## Loftus & Gipps St, Concord

### DA Stage Accessibility Assessment Report – BCA 2022

### Report 2025/1867 R1.1

Prepared for LFD Concord Pty Ltd  
January 2026

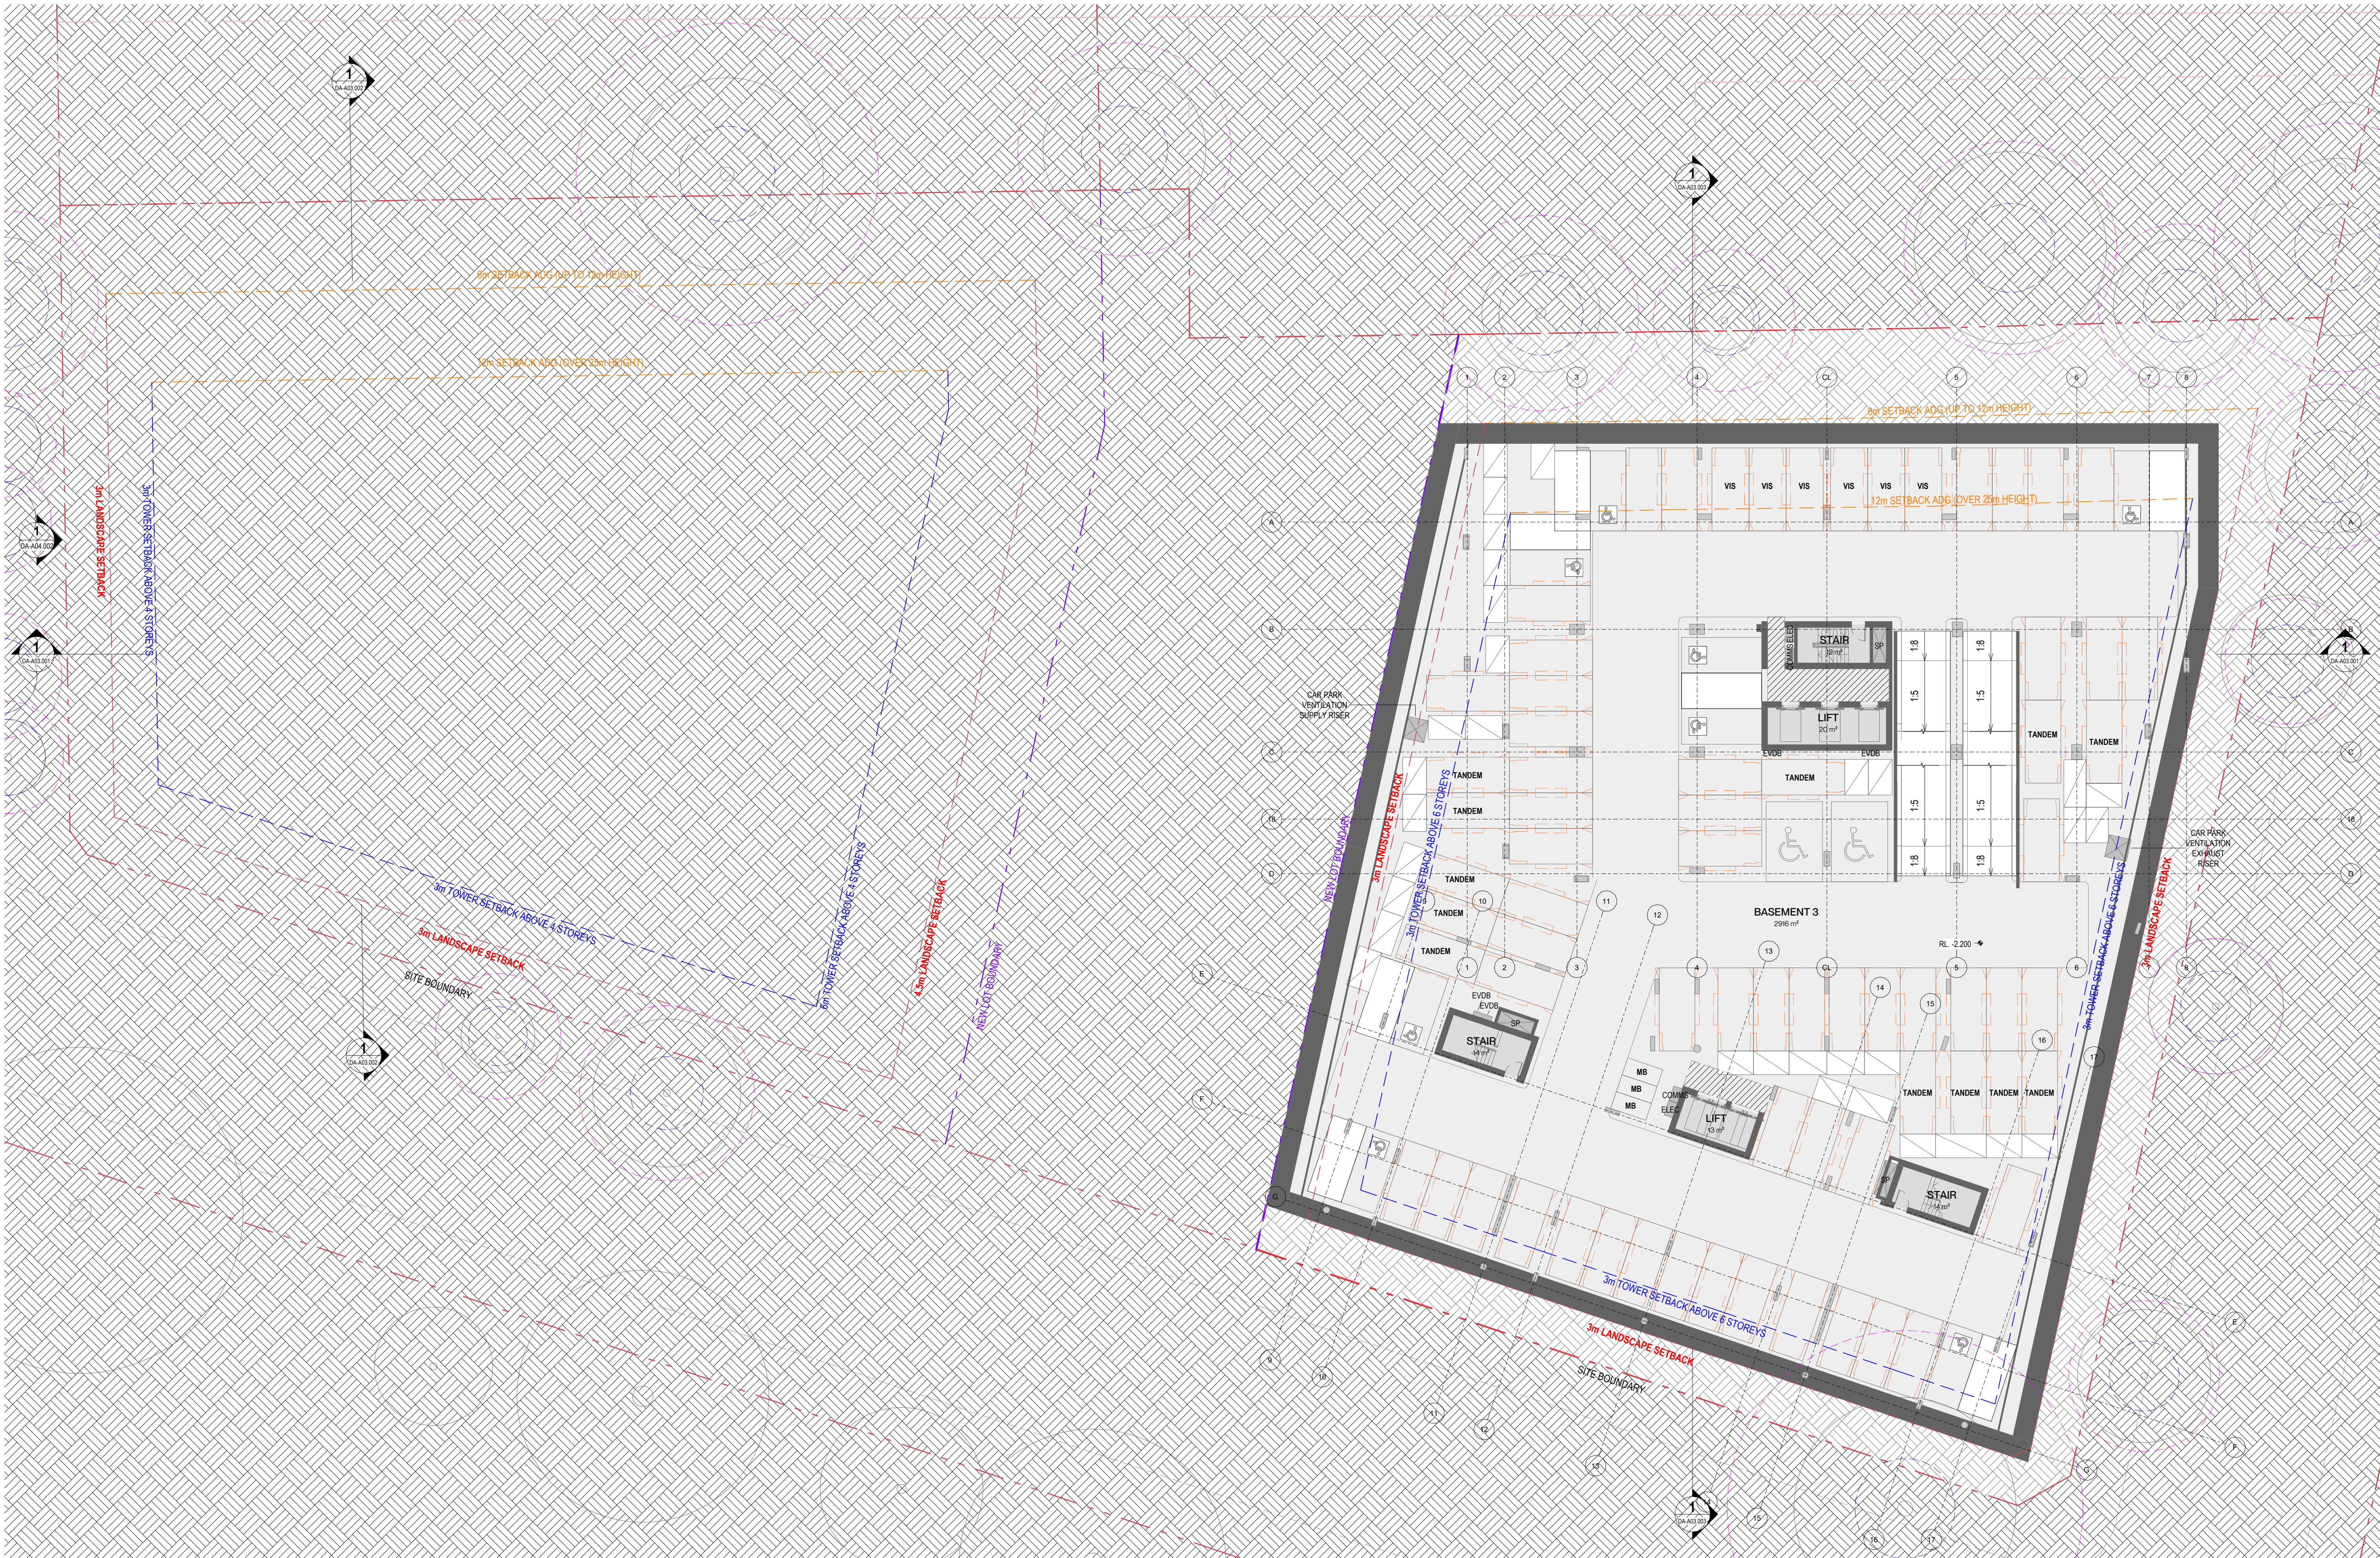
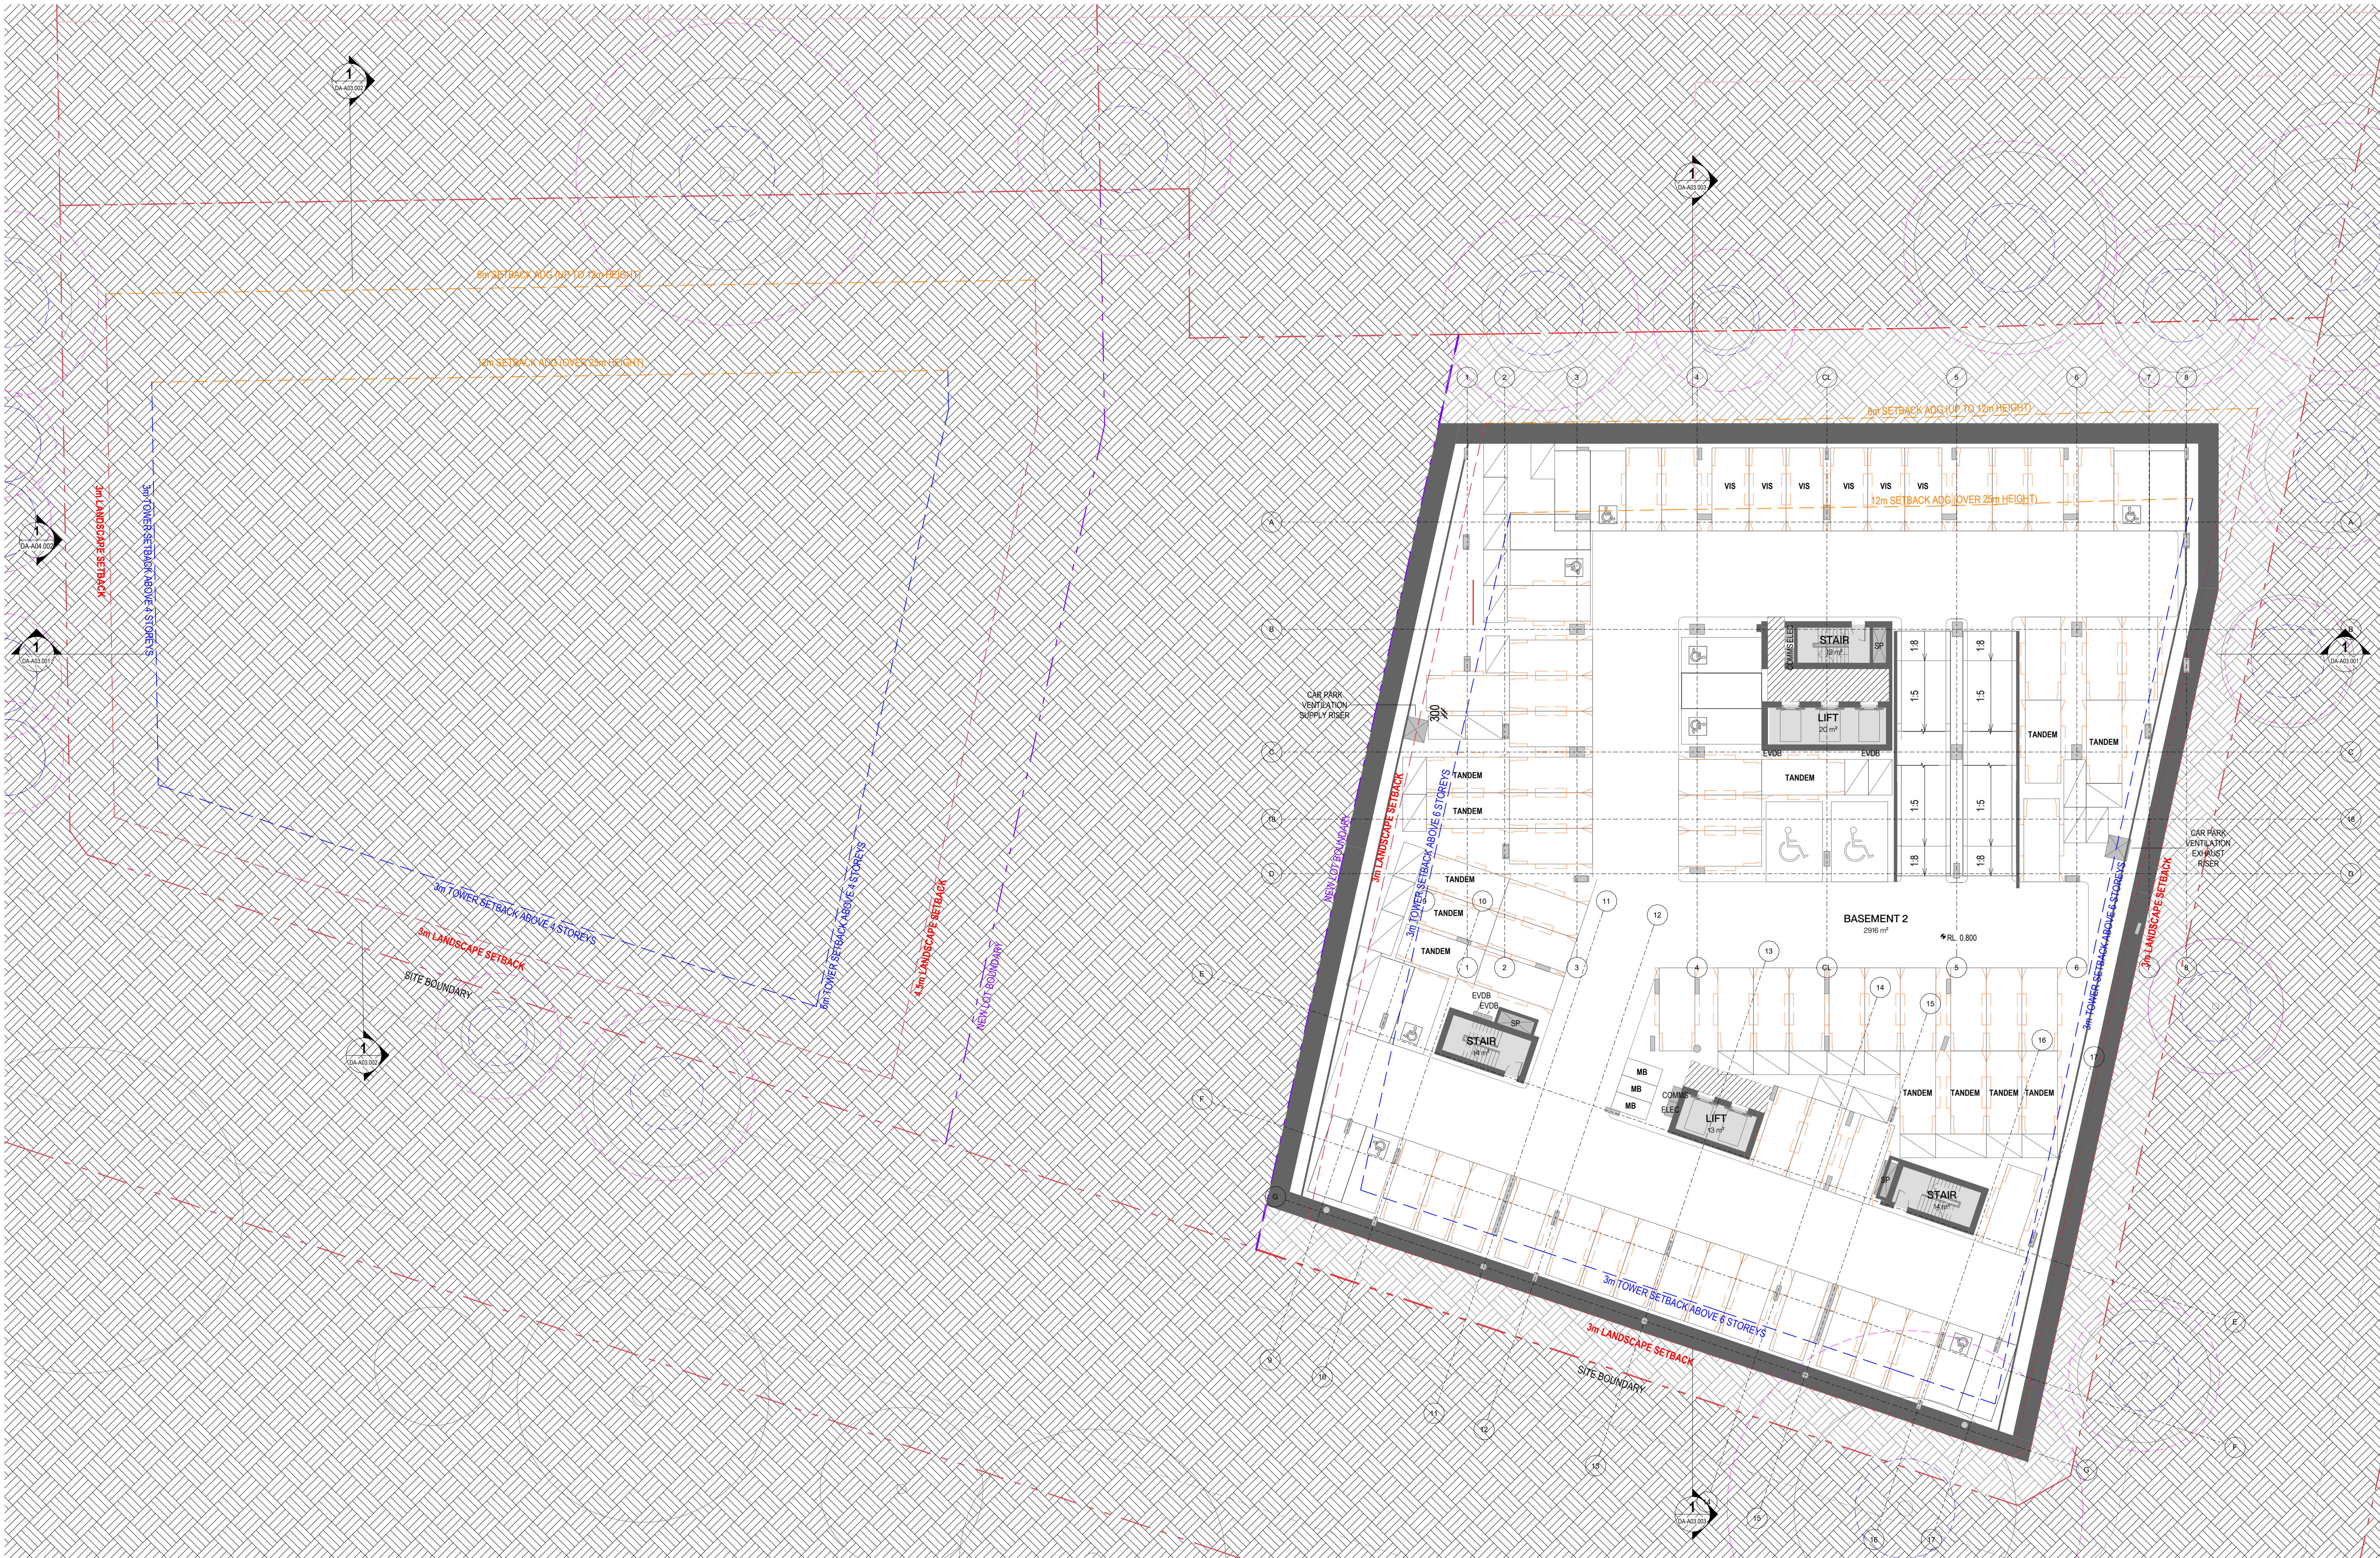
<b>Private Car Accommodation</b>			
<b>3.7.2</b>	Carparking space or garage min area 6.0x3.8m	There will be 34 adaptable units provided. The basement parking plans have provisioning for 34 accessible spaces that can readily achieve compliance with AS 2890.6. It is noted that AS 4299 requires an adaptable space to be 3.8m wide, therefore the adaptable units must also own the shared zone under the strata scheme to ensure the 3.8m wide space is complied with. This shall be confirmed at the CC stage.	Compliance Readily Achievable
<b>Accessible Entry</b>			
<b>4.3.1</b>	Accessible entry	To comply with door circulation spaces under AS1428.1, the entry door to the adaptable unit must have a minimum clear opening of 850mm and comply with AS 1428.1-2021 circulation spaces.  The post adaptation plans can readily achieve compliance with this clause with the exception of wheelchair circulation to airlock area – plans indicate approx. 1490mm whereby AS1428.1-2021 requires door circulation to be not less than 1670mm (latch side approach, door opens towards user).	Does Not Comply – Further design development required at CC stage
